# OXFORDSHIRE COUNTY COUNCIL'S RESPONSE TO CONSULTATION ON THE FOLLOWING DEVELOPMENT PROPOSAL

**Application no:** 22/02570/REM

**Proposal:** Reserved Matters application to 20/02083/OUT for the approval of details of layout (internal access roads and footpaths), scale, appearance and landscaping relating to the erection of 14 dwellings including 5 affordable dwellings, together with the provision of parking, landscaping and other associated details

**Location:** Hempton Gate Land North Of Hempton Road And West Of, Wimborn Close, Deddington

DRAWING TITLE:
PLOT 34 & 35
FLOOR PLANS AS PROPOSED

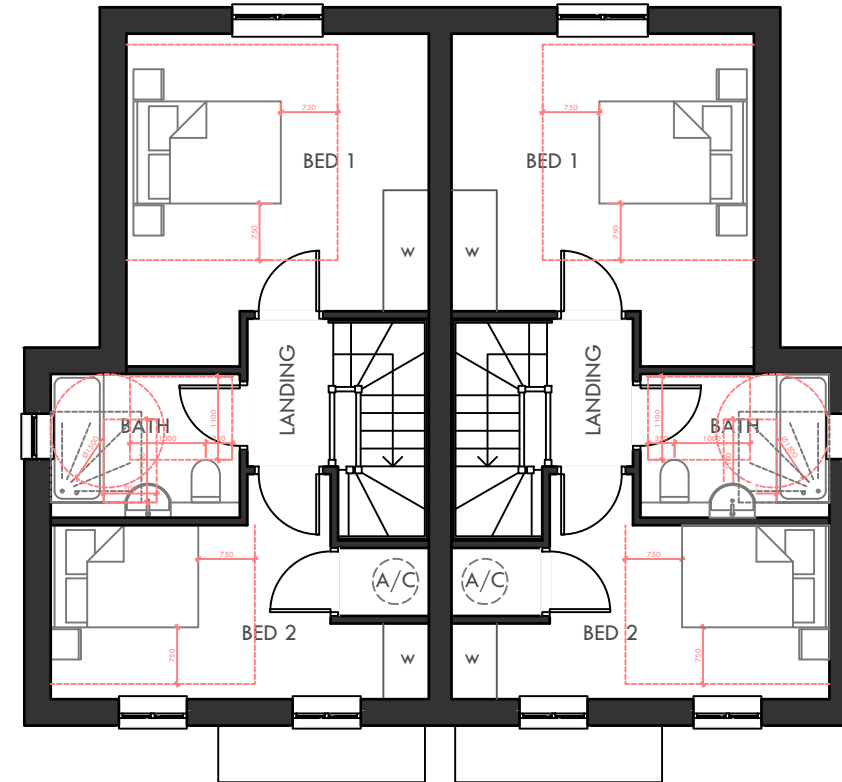
For those dwellings without garages, separate cycle parking facilities will be required. It is likely that this will be in a shed or similar in the garden. A revised route to the garden of Plot 35 is required so that it is not obstructed by parked cars.
